Listed Building Consent Delegated Report

Application No.	24/00752/LB
Site Address	Willow Cottage, Main Street, Wendlebury, OX25 2PW
Proposal	Erection of a fence and gates marking the boundary between Willow Cottage and the neighbouring property of Brookside
Amended Plans	None received

Willow Cottage, fence and gate located on western edge of property, running north/south.

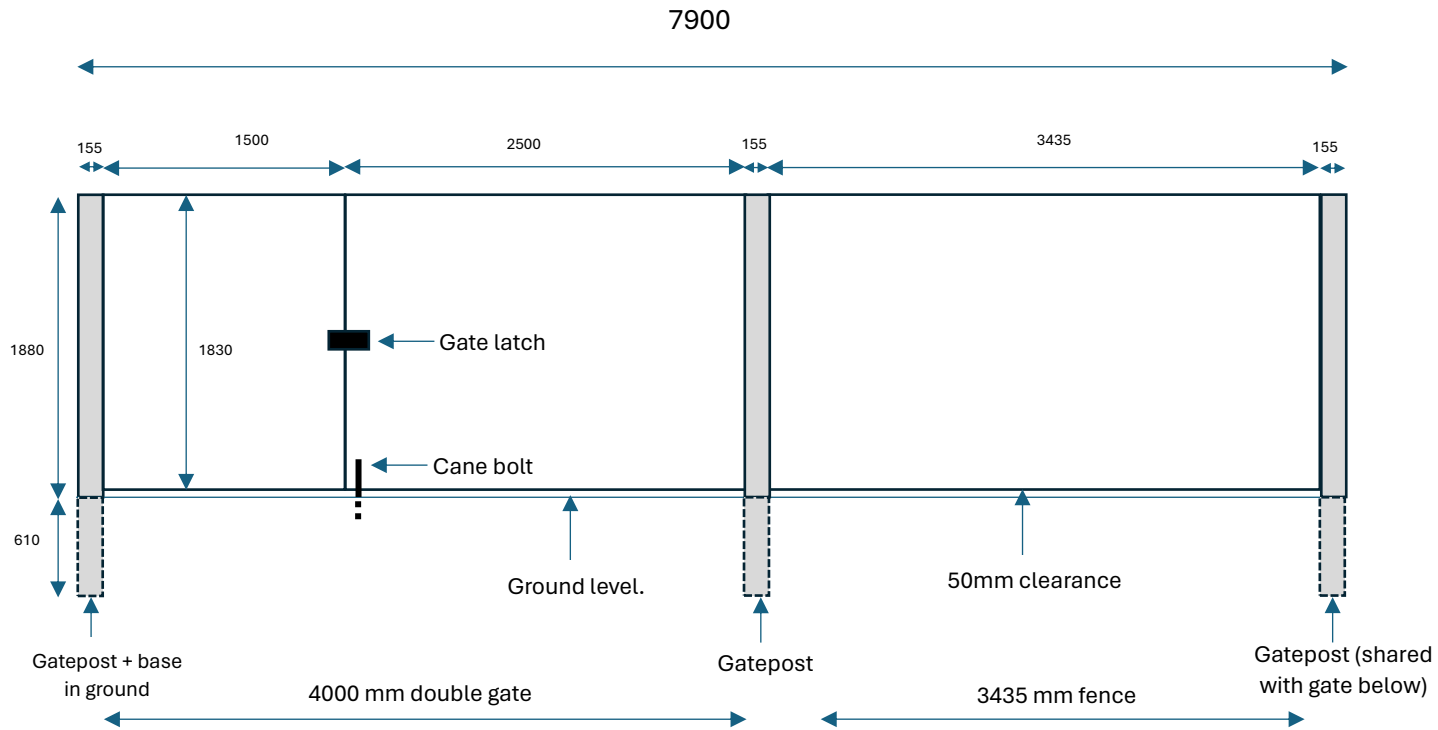
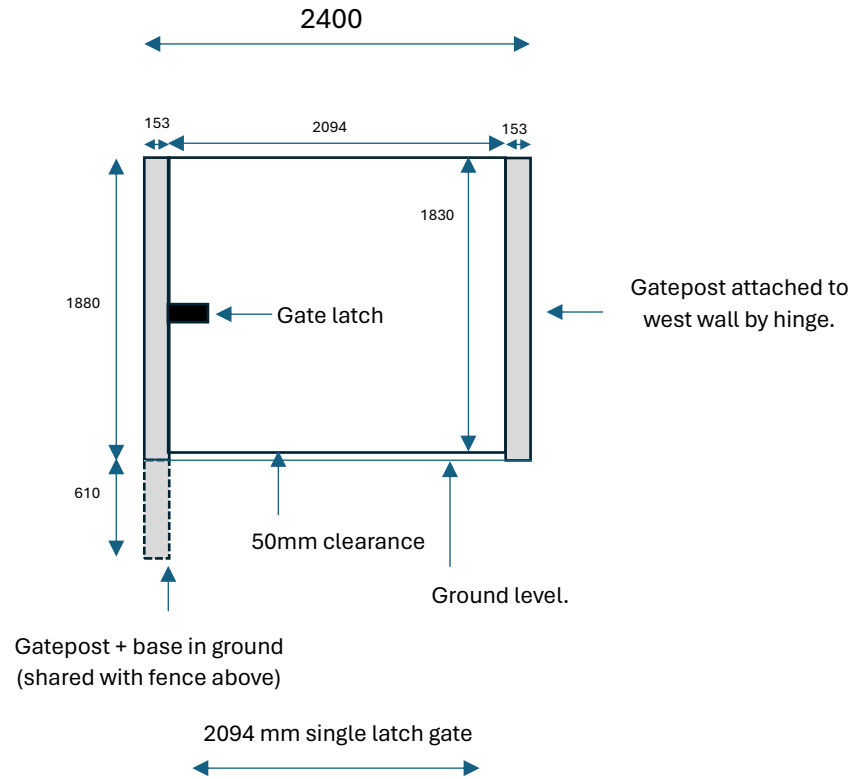
Consultees	<p>Clerk to Wendlebury PC - no objections Conservation (CDC)</p> <p>I have looked at your site photos and confirm I have no objection to marking the boundary to define ownership, but a close boarded fence would not be suitable for the setting of a listed building. I would also be concerned about the boundary being too high at 1880 based on how close it lies to the building.</p> <p>A matching stone wall or a robust traditional woven willow fence would be less urban, or a hedge could be planted alongside, and the fence removed once the hedge is established. A good willow fence was constructed at a listed building in Horton cum Studley a few years back, the image on the following link shows a good quality of fence being constructed:</p>  <p>The gates should be hung on sturdy timber posts to avoid fixings to historic fabric, subject to appropriate details/finish.</p>  <p>I would be grateful if you could seek a more appropriate boundary treatment.</p>

The Conservation Officer has objected to the fence/gates proposed, on the grounds that she considers that close boarded fences are not suitable for listed buildings and has asked that the applicant consider a wall or woven willow fence.

It is considered that the wall proposed would be impractical, as much the fenced area needs to be able to swing, to provide access over the neighbour’s right of access, and the woven fence would look extremely incongruous beside the existing wall and close boarded fences, adding yet another boundary type to the site, which would appear incongruous detract from the setting of the listed building, particularly given the small size of the garden.

It is also considered that since the garden already has close boarded fences, and a close boarded gate, re-instating the close boarded fences to the boundaries they had been removed from cannot be argued to harm the character or setting of the listed building, but would merely sustain its setting and historic significance.

On balance, it is considered that it would be unreasonable to refuse the gates and fences which would not harm the significance or setting of the listed building.
